Central Park

Outcomes Report on Block 11 Consultation

Client:
Fraser's Broadway Pty Ltd

Date:
28 October 2014

WELLINGTON STREET
SHADOW ANALYSIS JULY 21

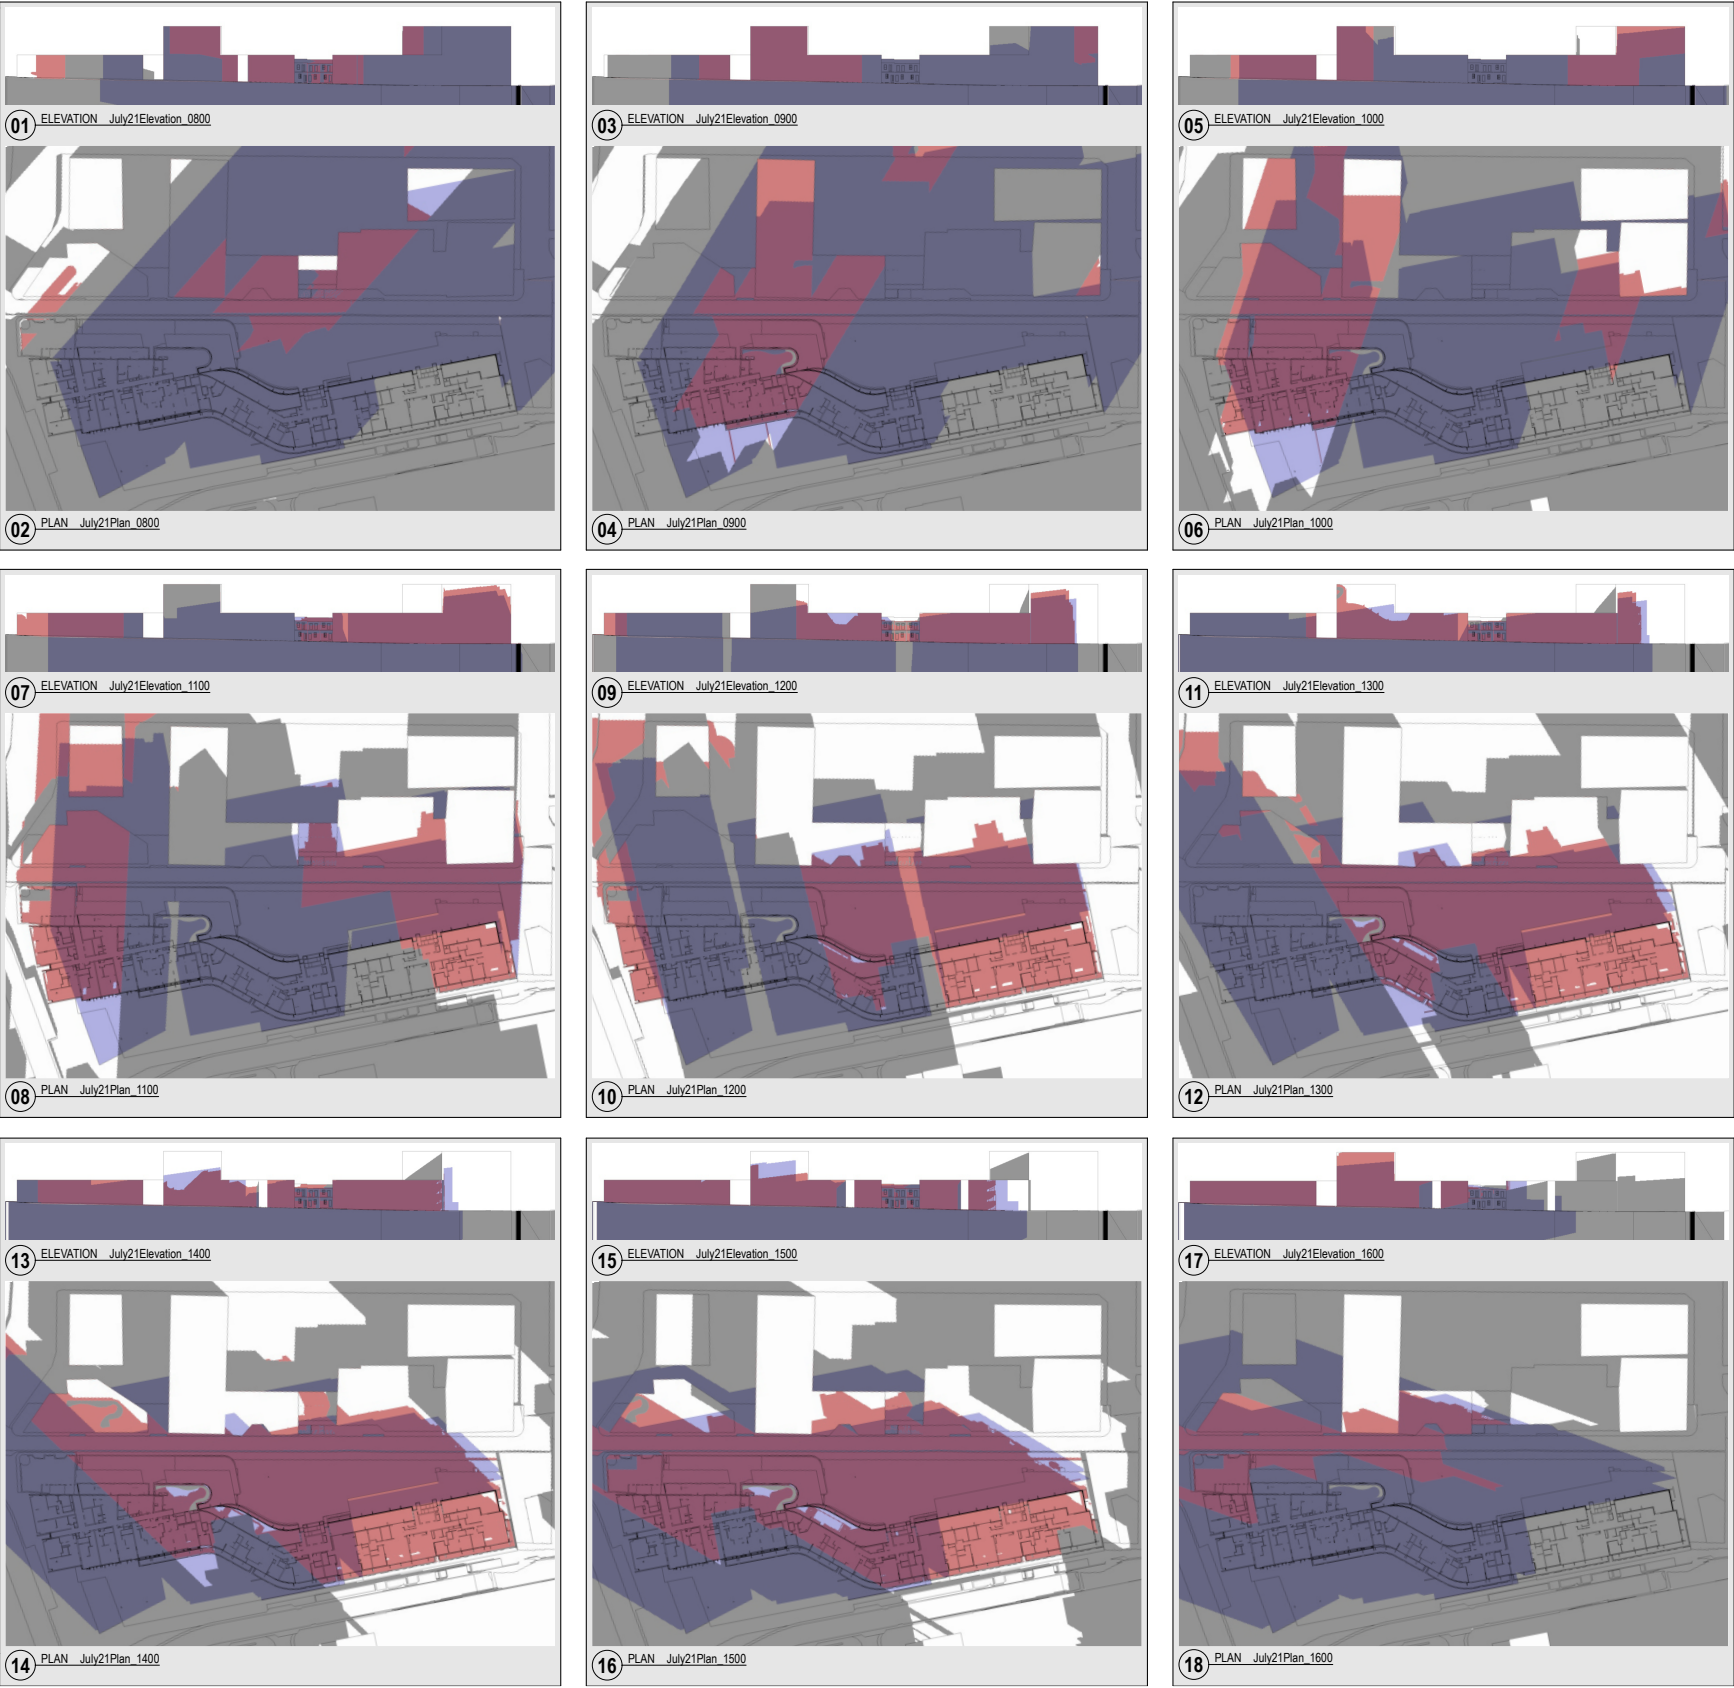
- » The **impact of shadowing on residents in Wellington Street** and any additional solar loss (when compared to the present situation) that the Block 11 building might create

What We Heard	Project Team Response
<i>Height, mass and impact</i>	
The impact of shadowing on residents in Wellington Street is a concern, and a request for more information around the impact	<ul style="list-style-type: none"> » The proposed design for Block 11 provides a better solar access outcome than the building form in the approved Concept Plan » This is due to the building form being pulled back from Wellington Street and its volume terraced at the top - optimising solar access » A solar access diagram demonstrating this difference specifically for the terraces on Wellington Street was drawn up since this request and was made public.
Reconsider the bulk and scale of the building	<ul style="list-style-type: none"> » The proposed design for Block 11 will sit within or on the plan boundaries of the approved concept plan. » Following detailed analysis of the approved concept plan envelopes it was identified that the proximity of the southern edge of the approved envelop significantly compromised amenity with respect to light access and the potential extent of public domain. » The new design proposes to sculpt the building mass to maximise the extent of public domain and optimise the access to natural light for to Wellington Street

07 SECTION Solar Analysis - Terraces
1:200
SOLAR ACCESS SECTION AT RESIDENTIAL TERRACES
Blue Text and line-work is relevant to the Modified Concept Plan
Orange Text is related to the Proposed Scheme

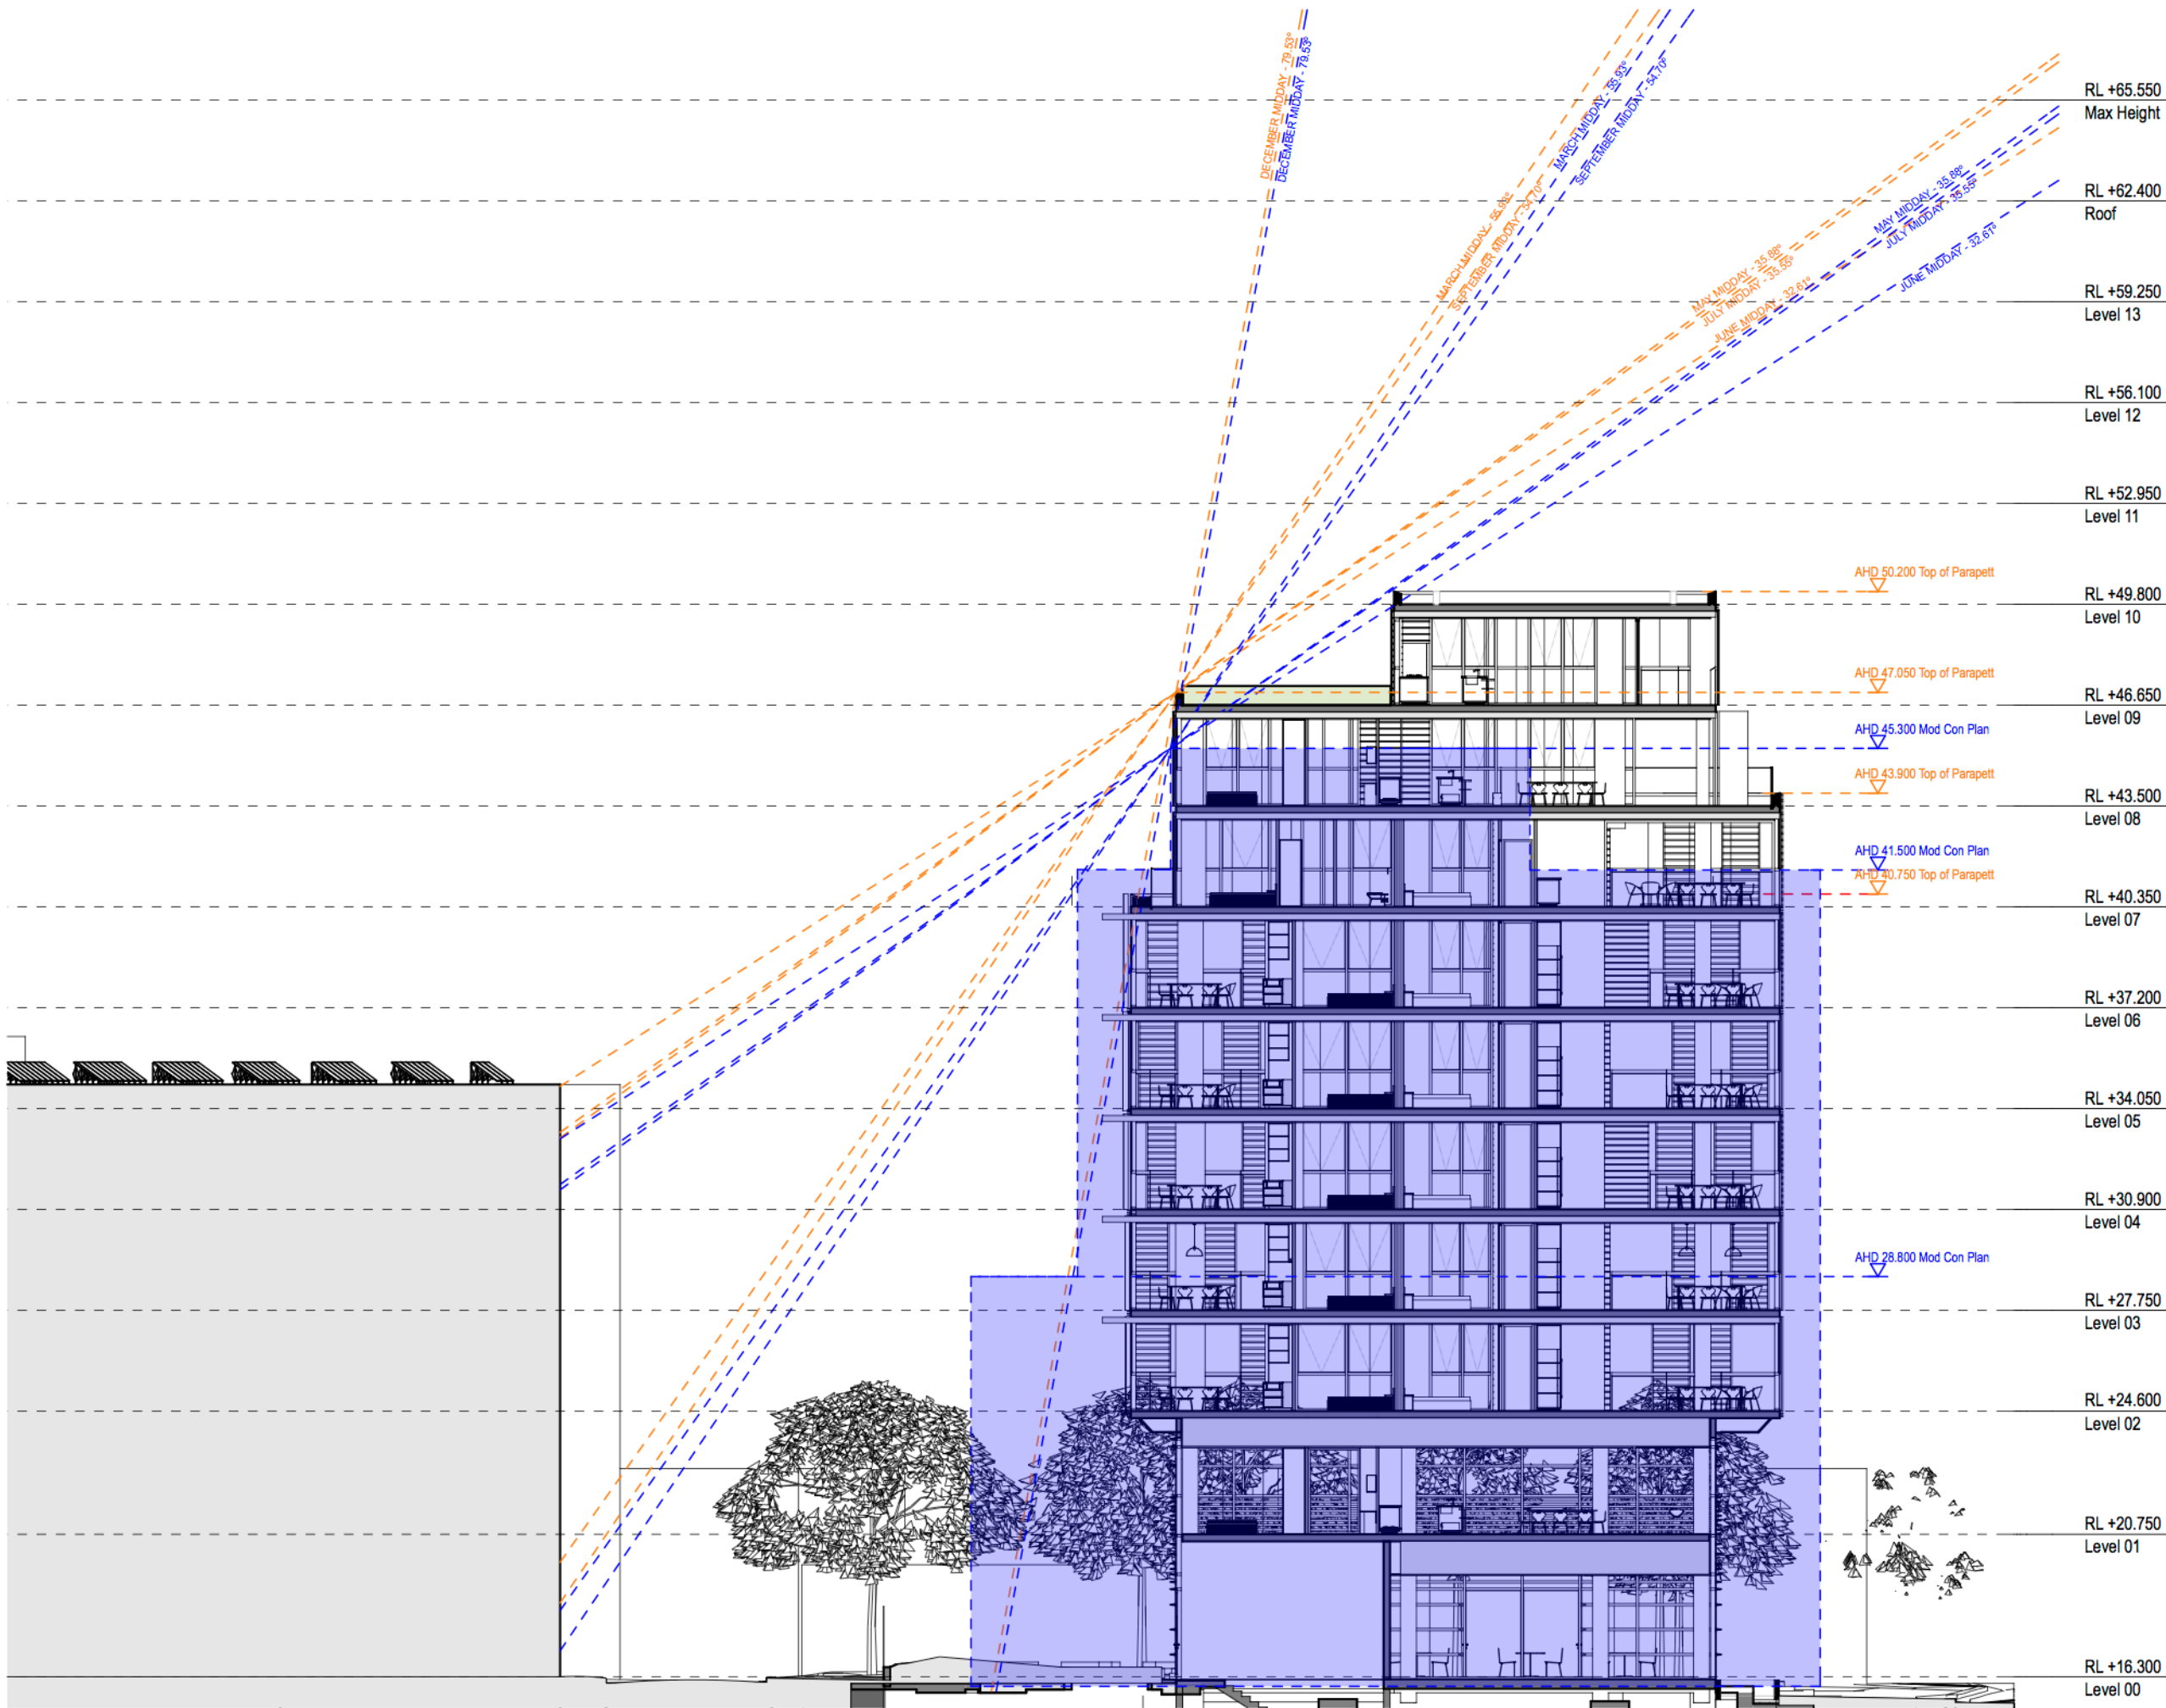
- » Concern regarding the **mass and height** of both the Concept Plan and proposed modification buildings. Particularly in relation to its impact on solar access, and on the appropriateness of its size in how it transitions to local buildings. A request was made for the exact height of the building at both the East and West ends and for a **solar diagram comparing current access to the proposal**. One respondent requested that the mass and height of the building be reduced.
